**City of Portland - Building or Use Permit Application**  
 389 Congress Street, #101 Tel: (207) 874-8703, Fax: (207) 874-8716

Permit No: 03-0669	Issue Date: <b>JUL 07 2003</b>	CBL: 339 D007001
-----------------------	-----------------------------------	---------------------

**Proposed Project Description:**  
 Amendment to Permit # 02-0995  
 26' x 34' Two Story Single Family with 22' x 24' garage

**Dept:** Zoning      **Status:** Approved with Conditions      **Reviewer:** Marge Schmuckal      **Approval Date:** 06/23/2003**Note:** third revision of this lot - last permit #02-0995**Ok to Issue:**

FOUNDATION / FIRST FLOOR FRAMING PLAN
SCALE: 1/4" = 1' - 0"

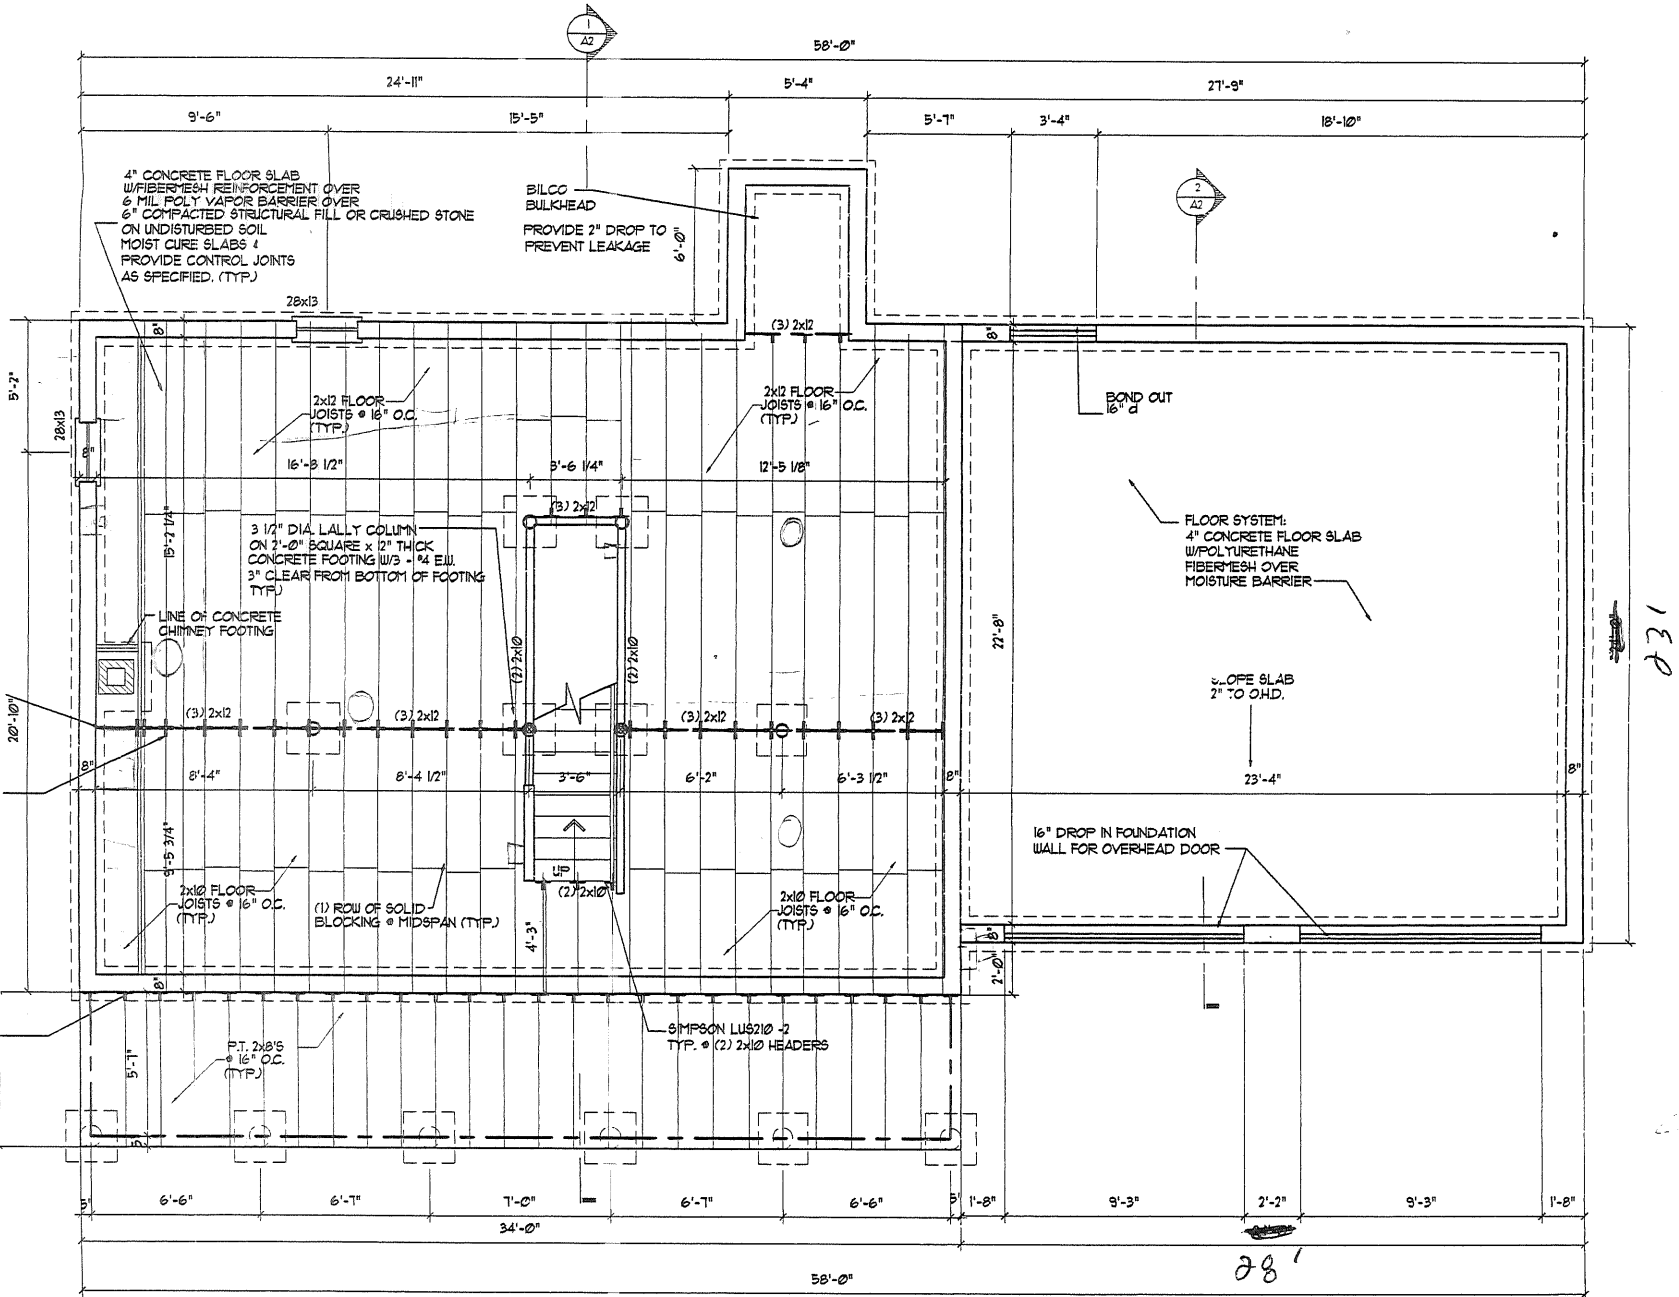
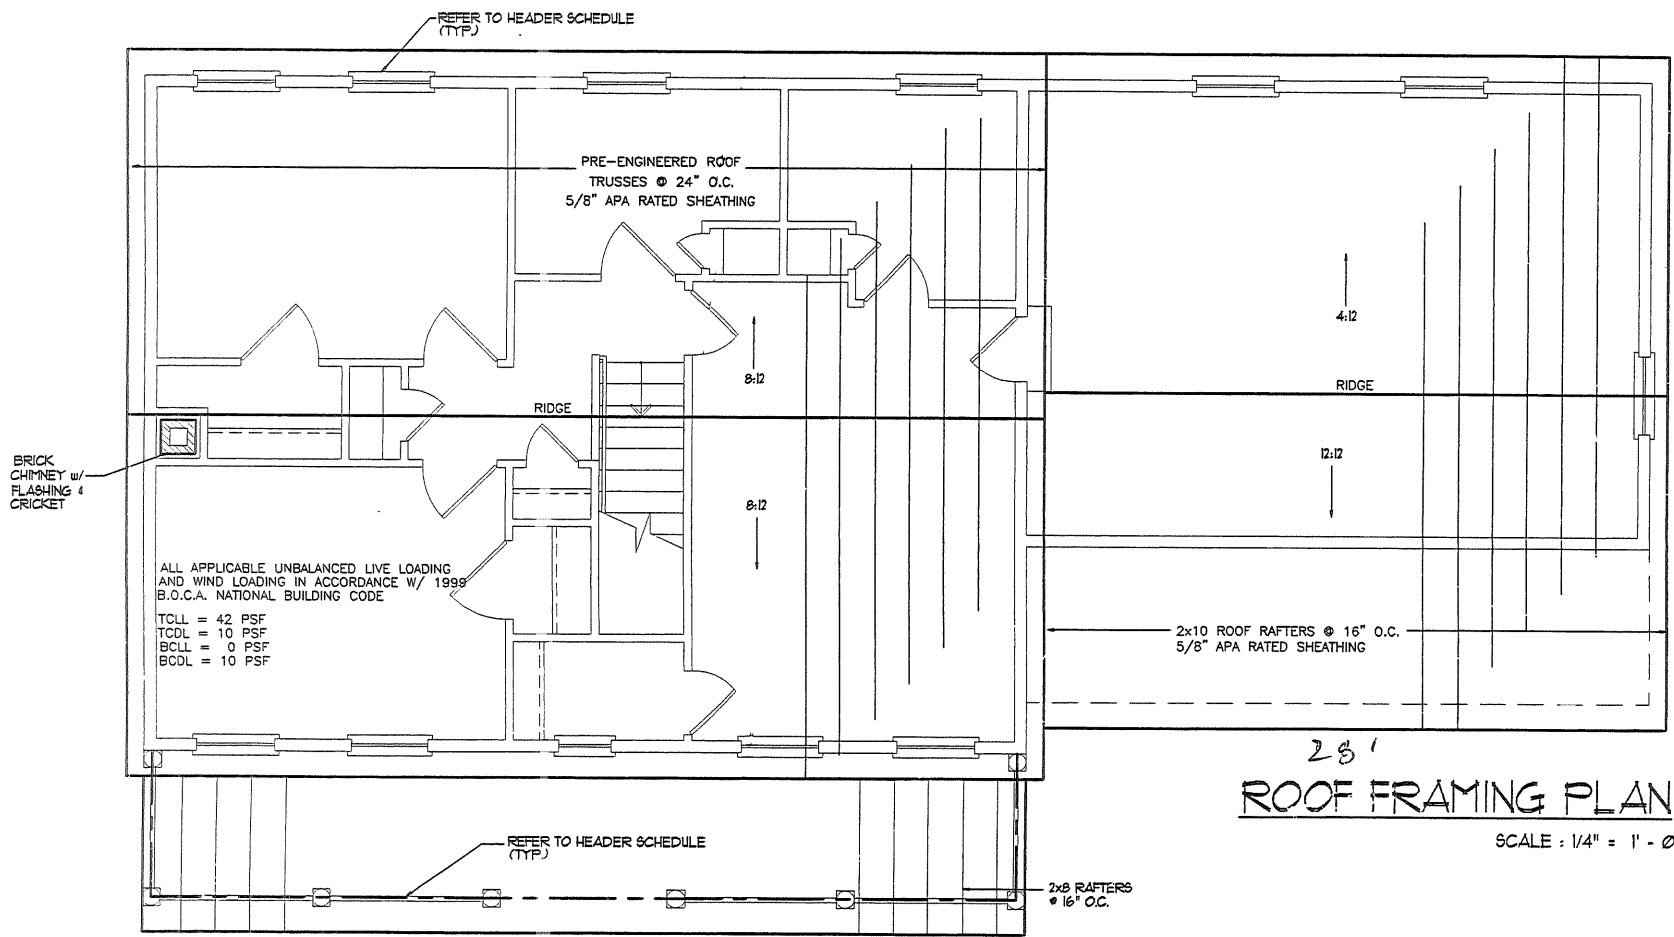
- 1) Maximum span for girder support is 7'-4", need to add 1, a 22x30 attic scuttle will be installed in a bedroom, paralam will be used for garage headers, all guards will be min. 36", less than 4" space w/handrails
- 2) Design load specs for all engineered products must be submitted to this office
- 3) Separate permits are required for any electrical or plumbing work.
- 4) Application approval based upon information provided by applicant. Any deviation from approved plans requires separate review and approval prior to work.
